**KIRKLEES METROPOLITAN COUNCIL
INVESTMENT & REGENERATION SERVICE**

DELEGATED DECISION TO DETERMINE PLANNING APPLICATIONS

Reference No:	2025/62/92021/W
Site Address:	Globe Arts Studio, Carr Lane, Slaithwaite, Huddersfield, HD7 5AG
Description:	Change of use of part of first floor from non-residential education (F1) to dental practice (E(e)), installation of replacement entrance door, reinstatement of rear door opening and installation of air conditioning condenser units within the roofscape (within a Conservation Area)
Recommending Officer:	Danielle Cooper

Reference: 2025/92021

P1 Proposed Elevation Carr Lane (NW)
1 : 100

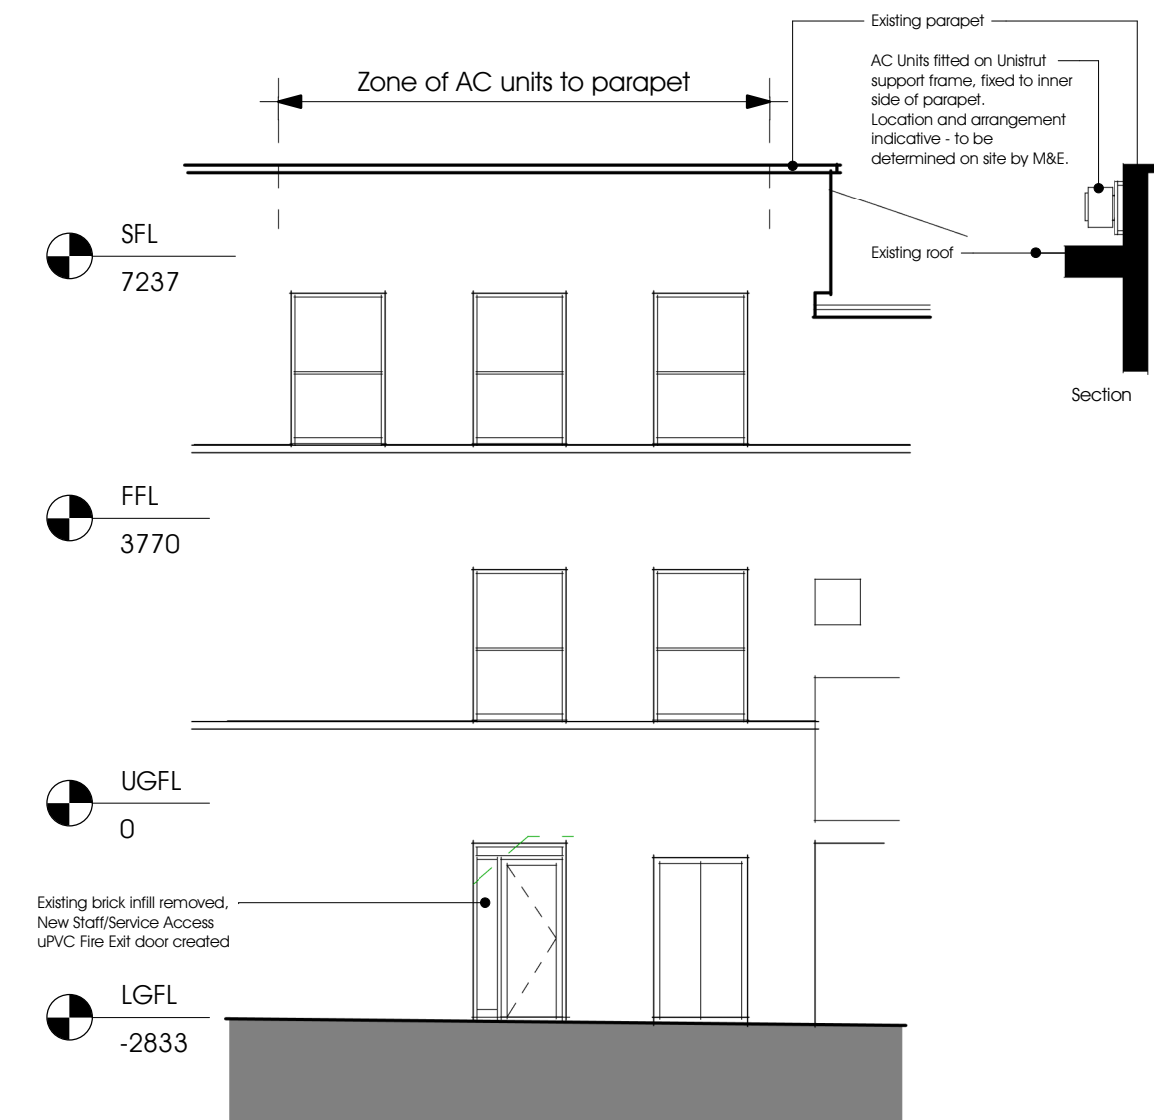
The replacement main entrance door on Carr Lane will substitute an existing modern entrance. Given this context, the design and glazing of the new door are considered to be visually acceptable and in keeping with the appearance of the building.

The new windows and door facing new street will be uPVC to match the existing fenestrations and the new entrance door facing Carr Lane will be timber which is considered visually acceptable.

The proposed full-length windows, the addition of window curtaining to existing openings, and the inclusion of obscure glazing to the surgery windows (as indicated on the submitted plans) are considered to be visually appropriate interventions. These works would not result in harm to the character or appearance of the building or the wider Slaithwaite Conservation Area. It is also noted that the ground floor openings on this elevation have previously been modernised.

P6 Roof Plan
1 : 200

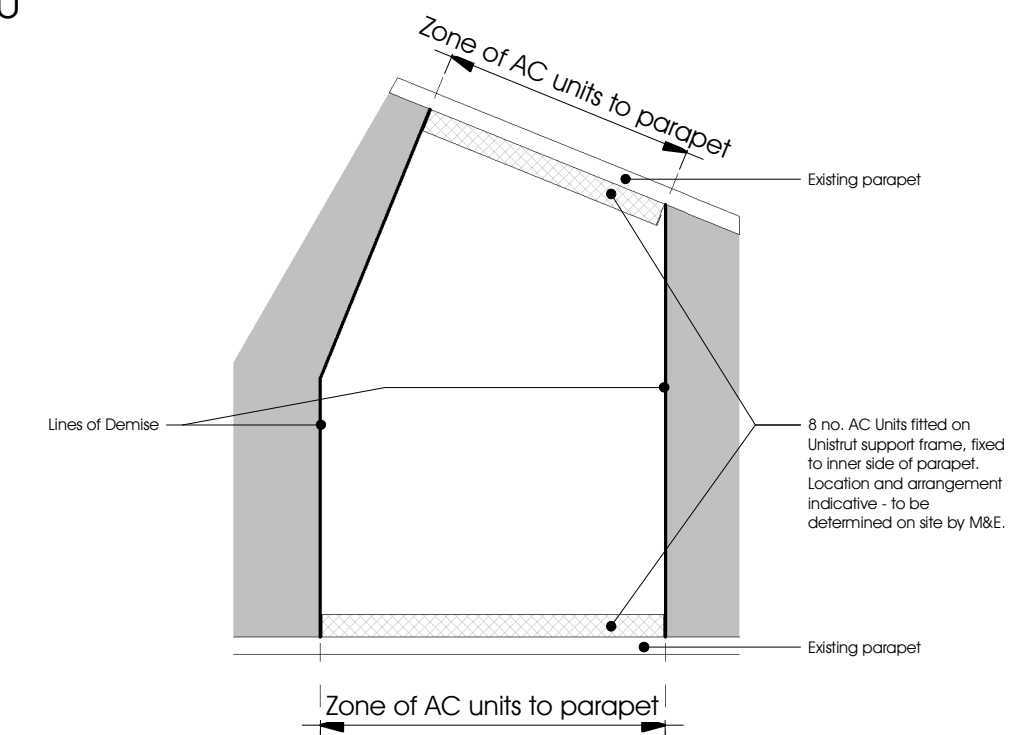
Officers requested the relocation of the proposed AC units to be within the roofscape to ensure the character and appearance of the building is protected. The agent submitted revised plans to show the AC units within the roofscape of the building.

In addition, the proposed air-conditioning units are to be installed on the roof parapet, where they will not be visible from public vantage points. This discreet positioning is considered acceptable and will preserve the character and appearance of the conservation area.

The proposal also includes the reinstatement of a previously infilled door opening on the rear (New Street) elevation to provide a staff-only access point. The proposed door is considered to be visually acceptable and would not detract from the overall appearance of the building.
